Consultation Response from KC, Highways Development Management

2022/92406 Land Adj, 67, Chapelgate, Scholes, Holmfirth, HD9 1SX

Erection of 10 affordable dwellings, with access from Chapelgate and associated works, including resident play zone

Date Responded: 05/09/22

FIGURE 3

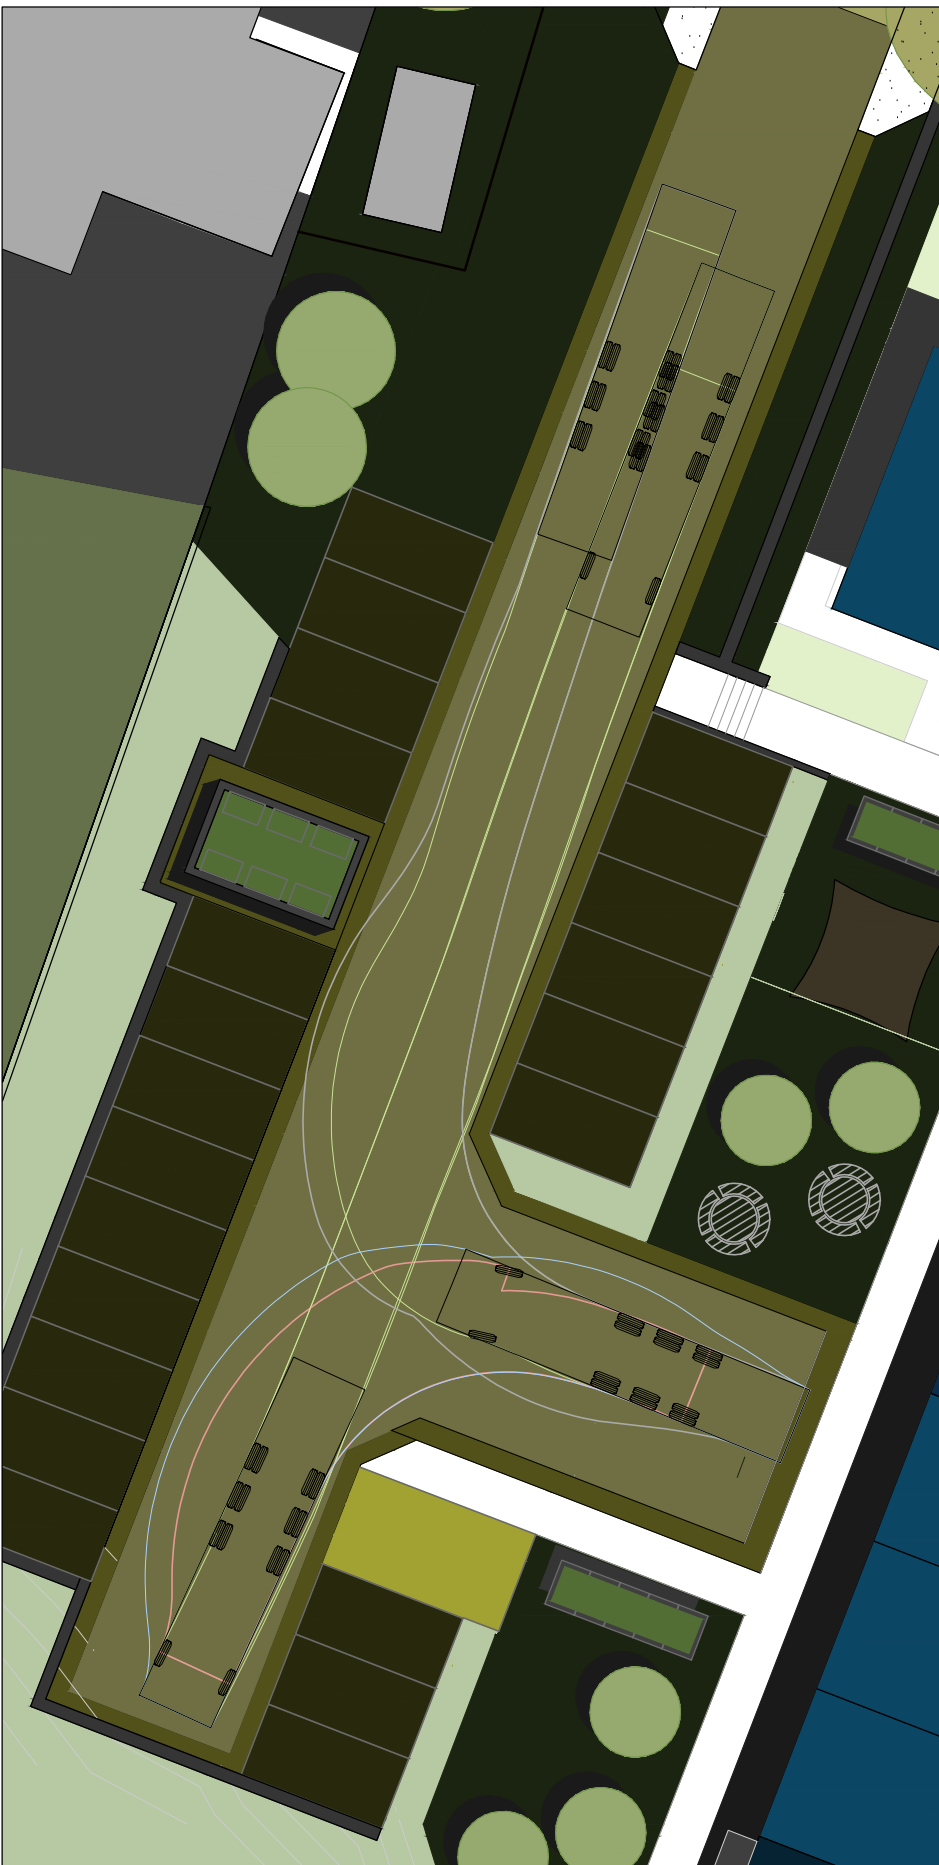
Whilst the development appears for the most part to conform to the standards set out in Kirklees' Highway Design Guide SPD, Highways DM would ask that a 0.5m clearance from the edge of the carriageway is maintained when vehicles are turning. Given the submitted swept-path analysis, it would appear that the tracking does not follow this guidance outside plot 9 and next to parking bays 5 and 6.

- An amended plan allowing for a 0.5m clearance from the carriageway edge to be maintained at all times by an 11.85m refuse vehicle entering and exiting the site in a forward gear.
